SMOKE STACK AT STERLING RANCH

RR-2.5 REZONE

SMOKE STACK AT STERLING RANCH REZONE

V1_ zone map.pdf Markup Summary

# SMOKE STACK AT STERLING RANCH

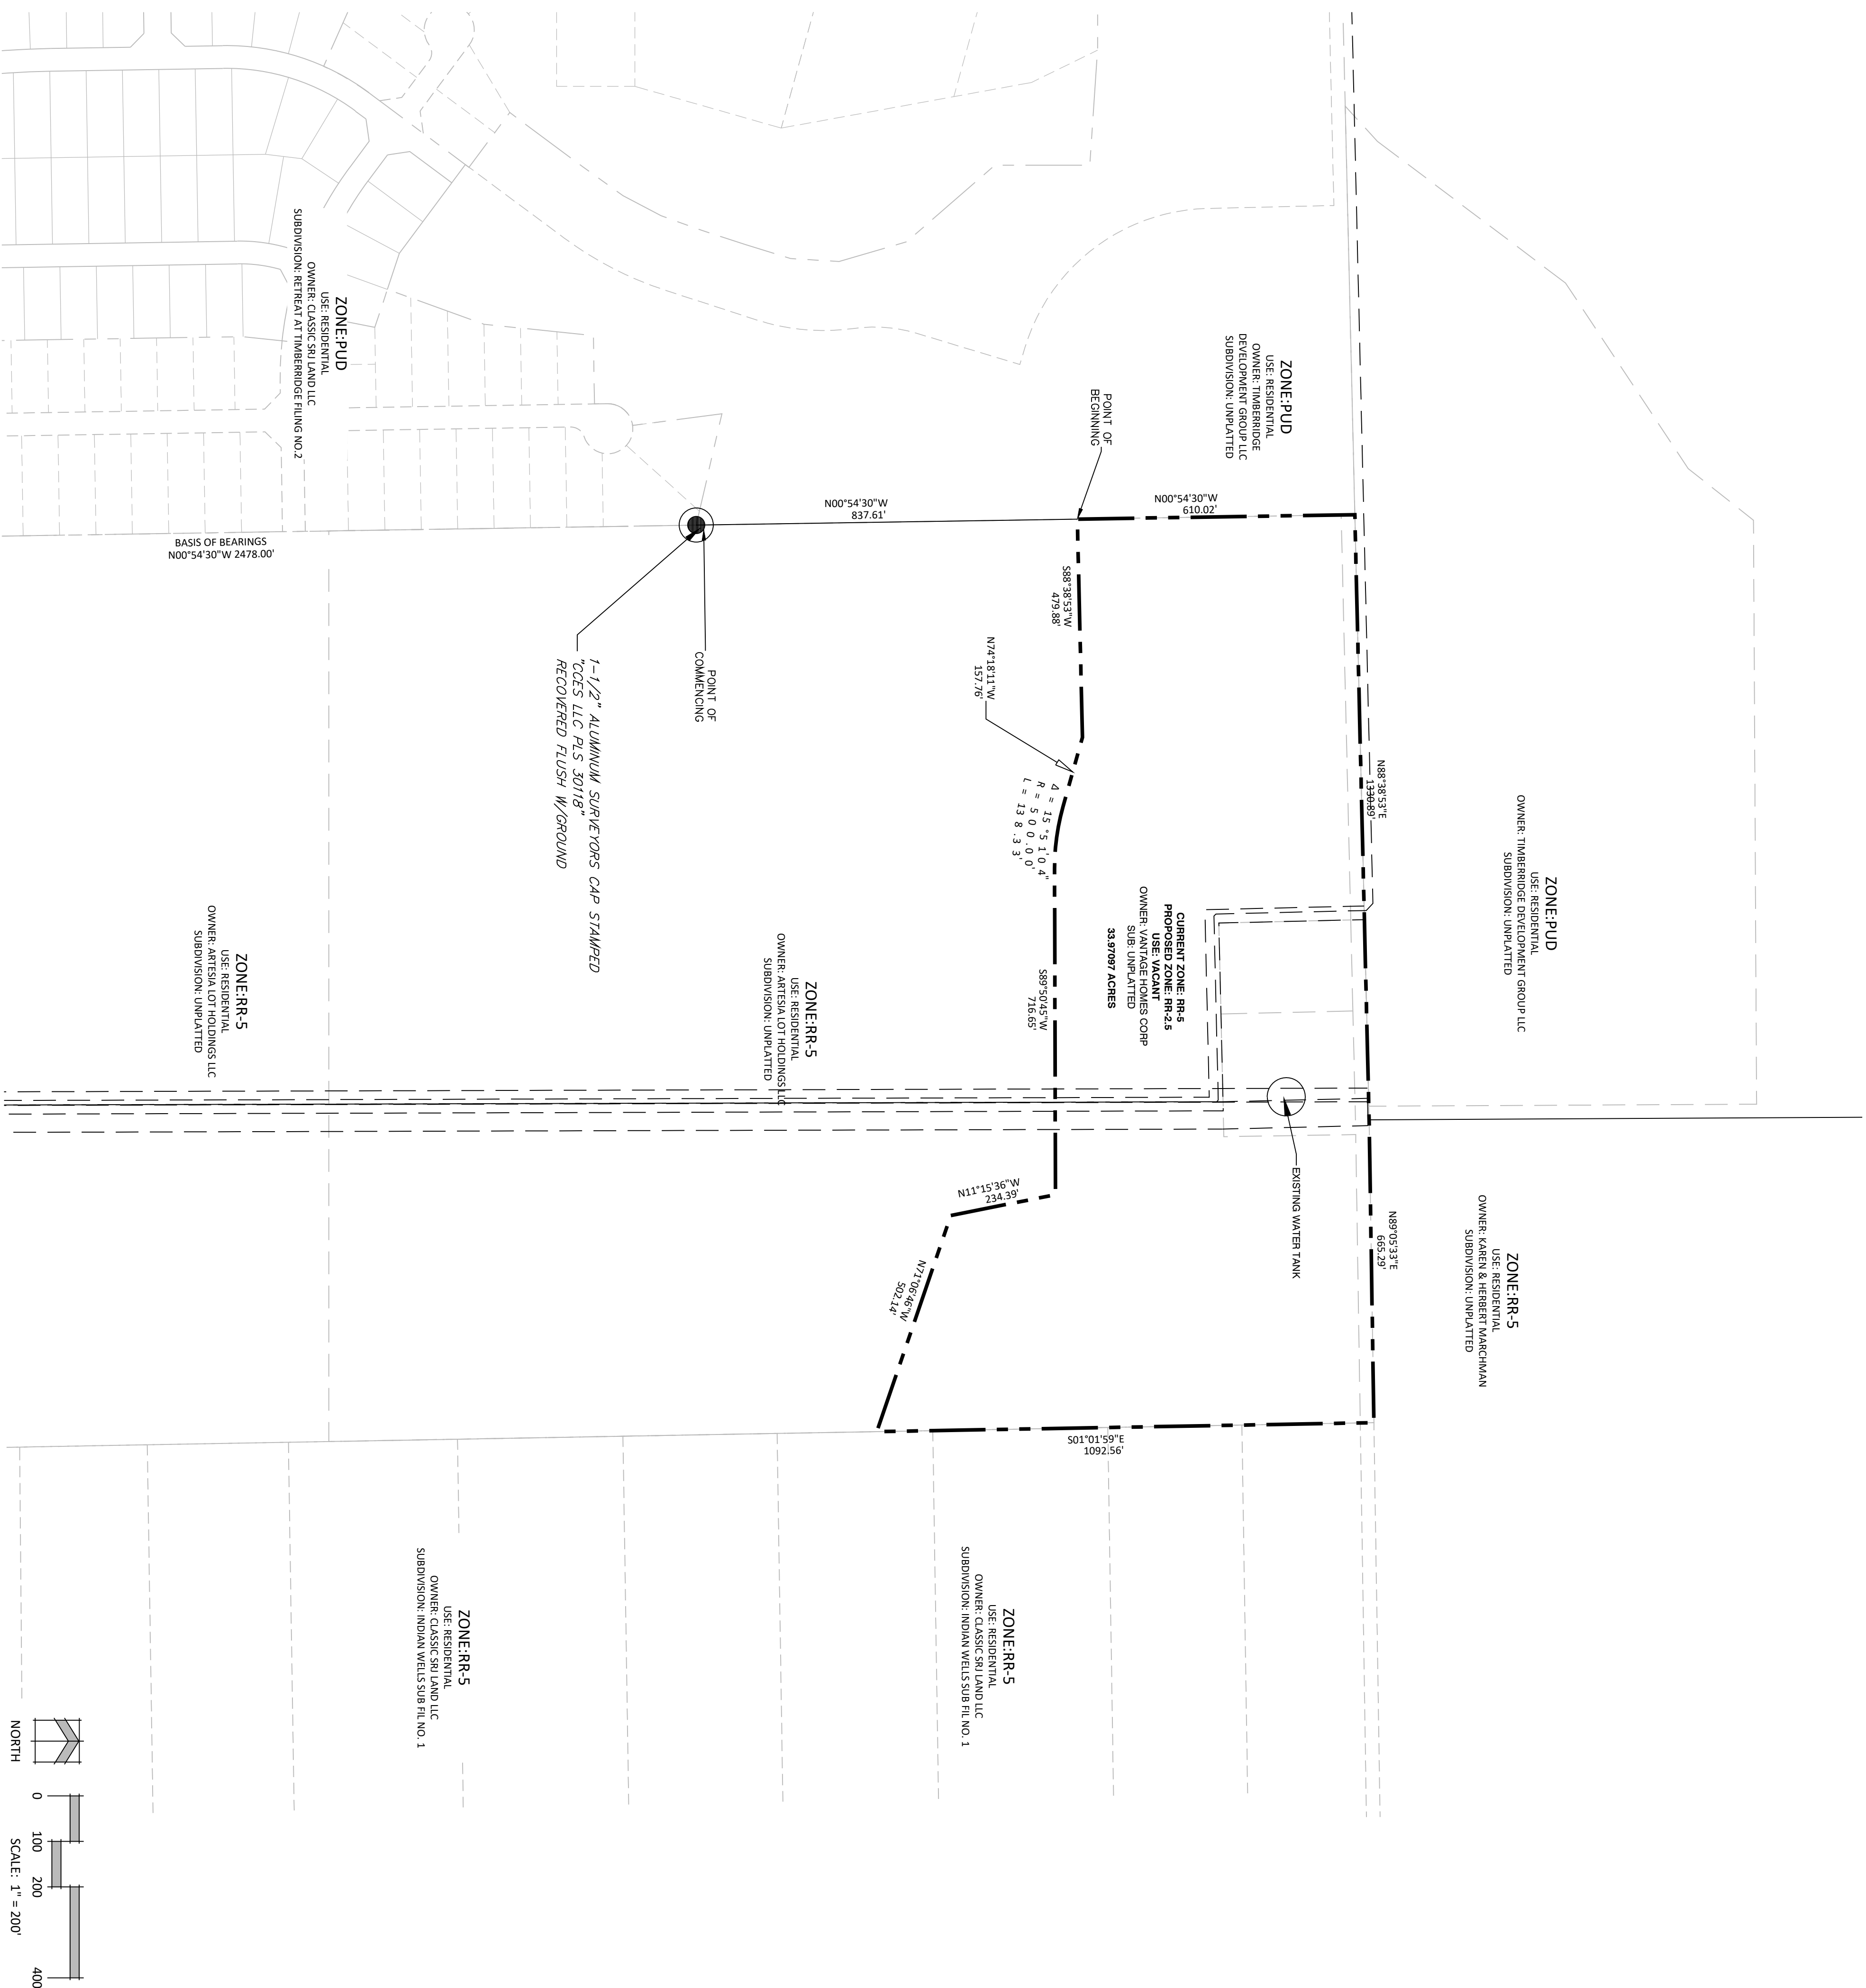
provide acreage

please identify subdivision names for clarity

Add existing roads, structures, easements, etc. per checklist please

EASEMENT
